# CITY OF ALBUQUERQUE

February 8, 2012

**Re: Plaza at San Mateo, Tract A Vidas Subdivision  
2403 San Mateo, Grading and Drainage Plan  
Engineer's Stamp Date 1/31/2012 (H17/D103)**

**GRADING PLAN**  
C201

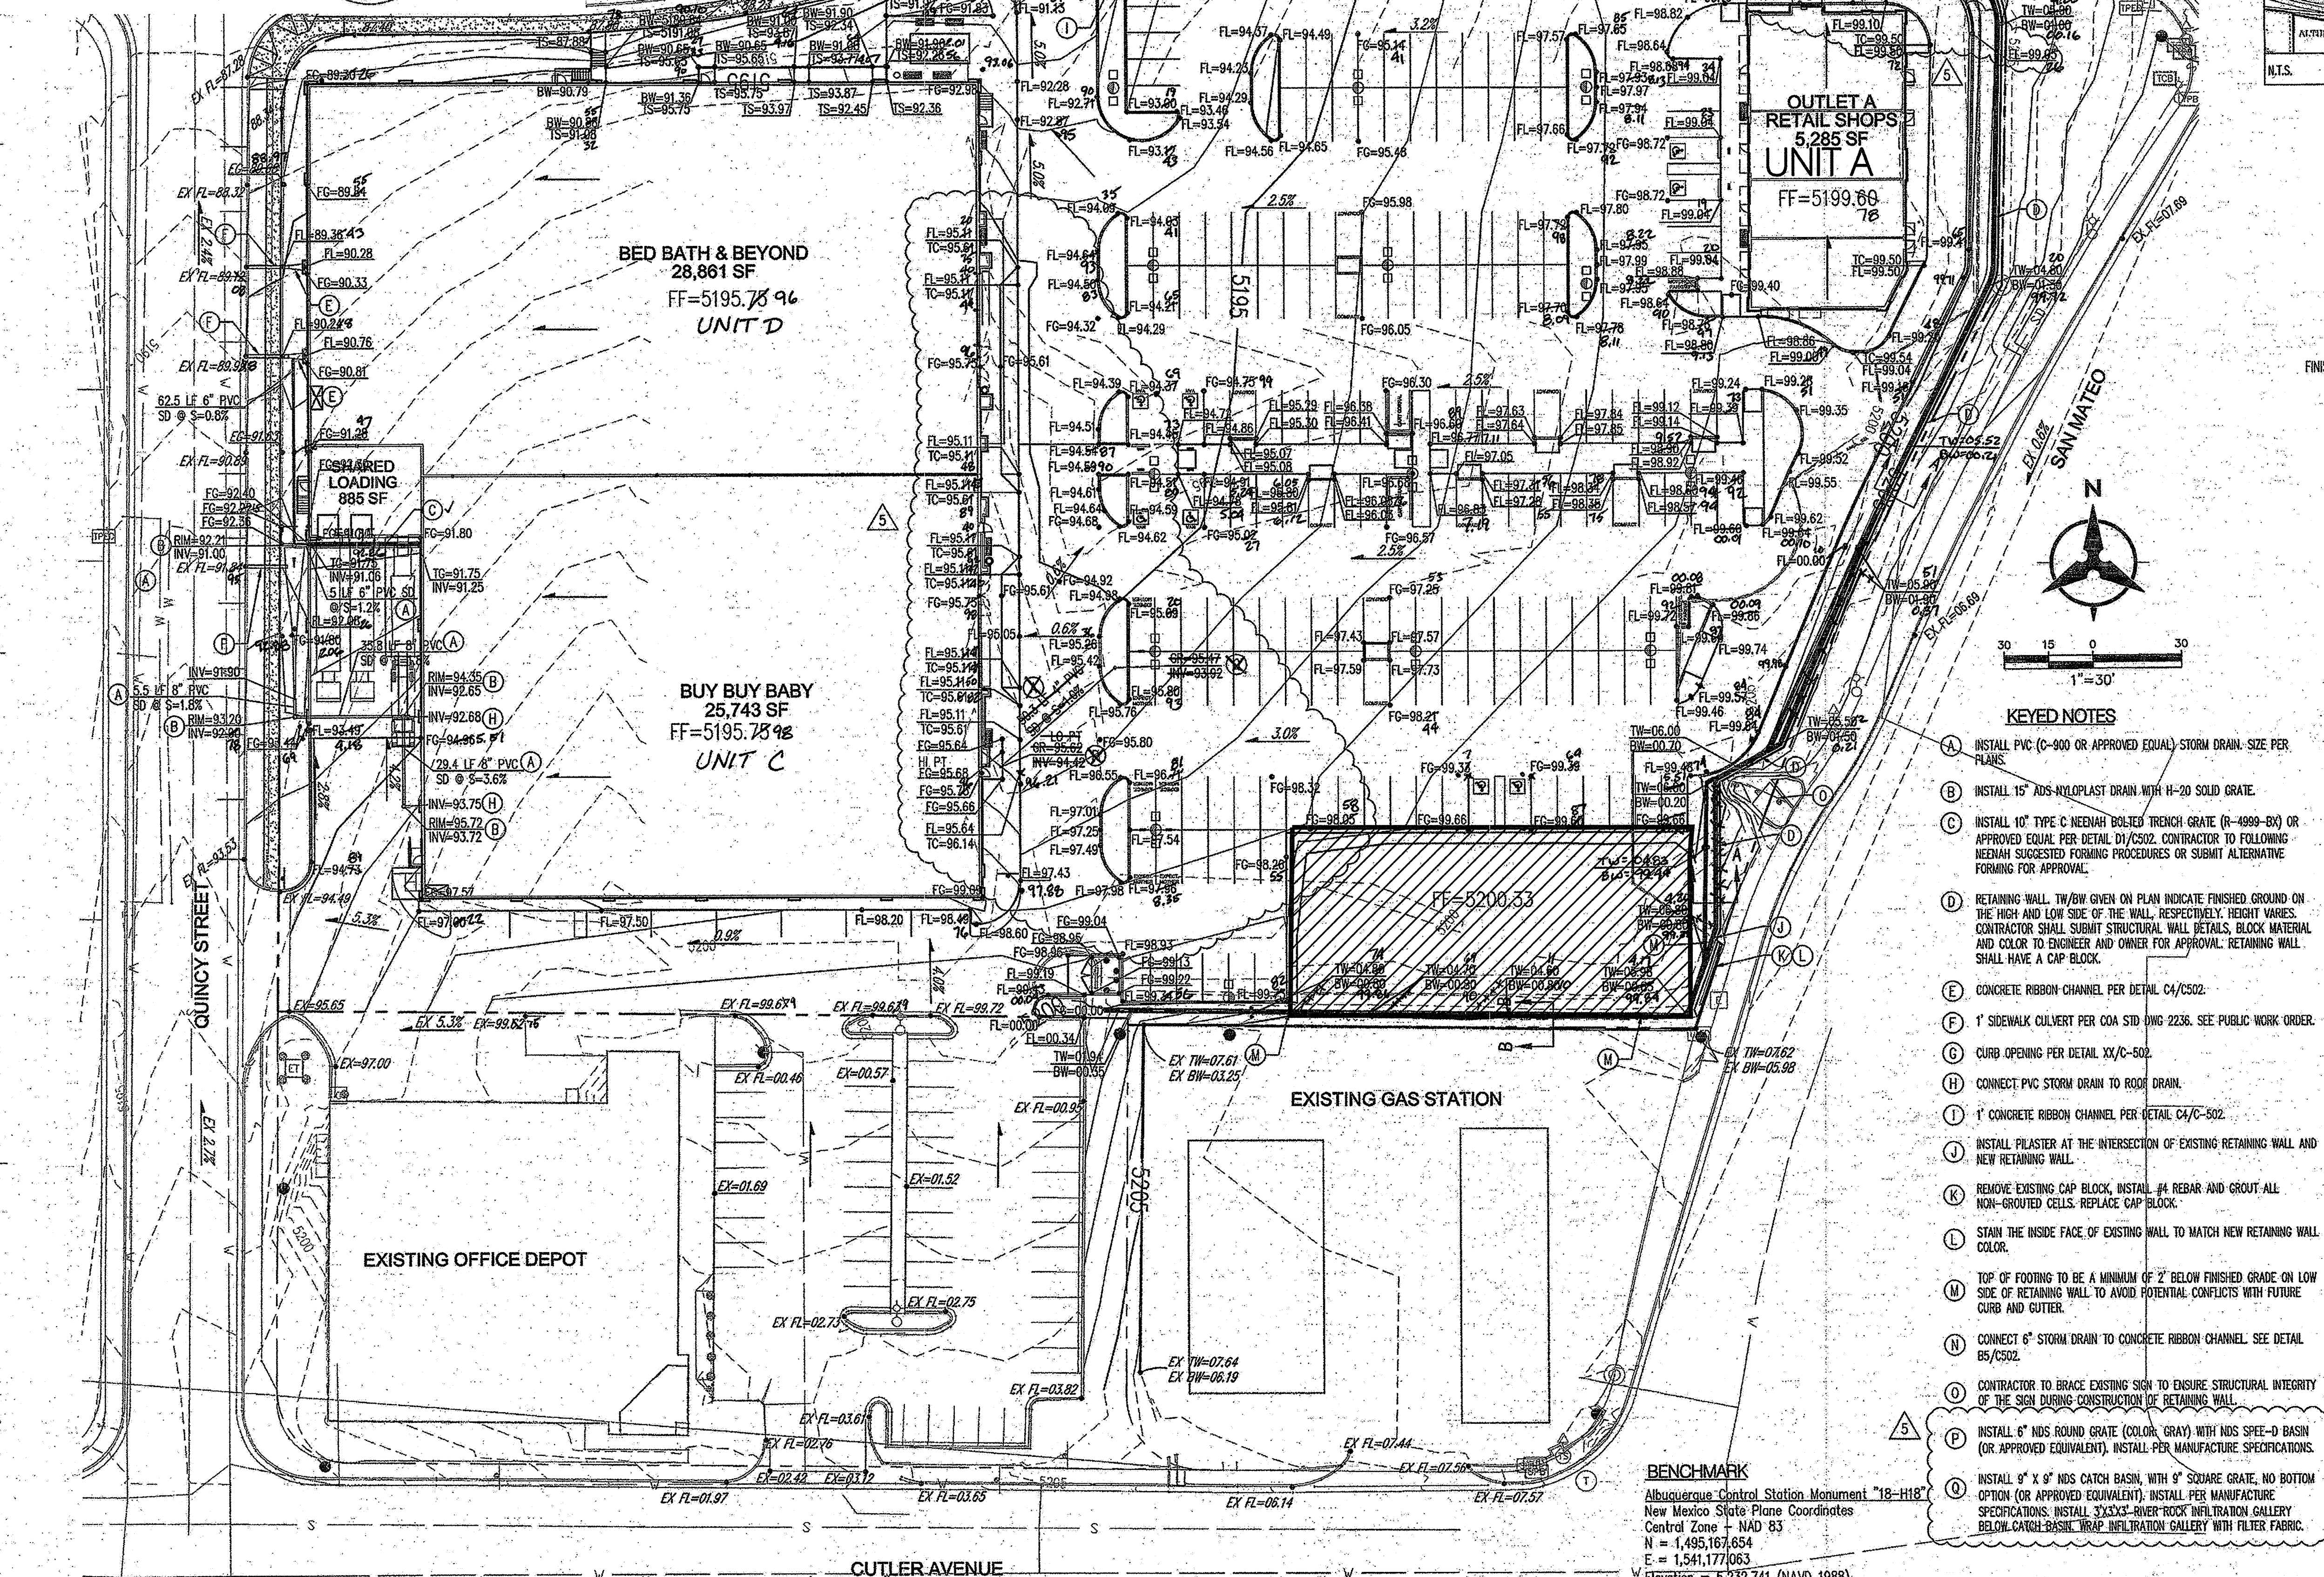
- Proposed retaining wall south side of Outlot B building may have to be extended west.
- Provide spot elevations on the south and east side of the Outlot B building.
- Appears that double retaining wall is shown for small area east of Outlet A building. Please provide TW/BW elevations.
- How will the loading area south side of the Bed Bath & Beyond drain? Provide more spot elevations for this area.
- An area northeasterly corner of the Bed Bath & Beyond building flows west. Where is the runoff draining to?
- Use sidewalk culverts and depressed landscaping areas to avoid draining the runoff over the sidewalks. Provide more spot elevations west and north side of Bed Bath & Beyond and Buy Buy Baby buildings.
- SO-19 notes will be required if sidewalk culverts are proposed.
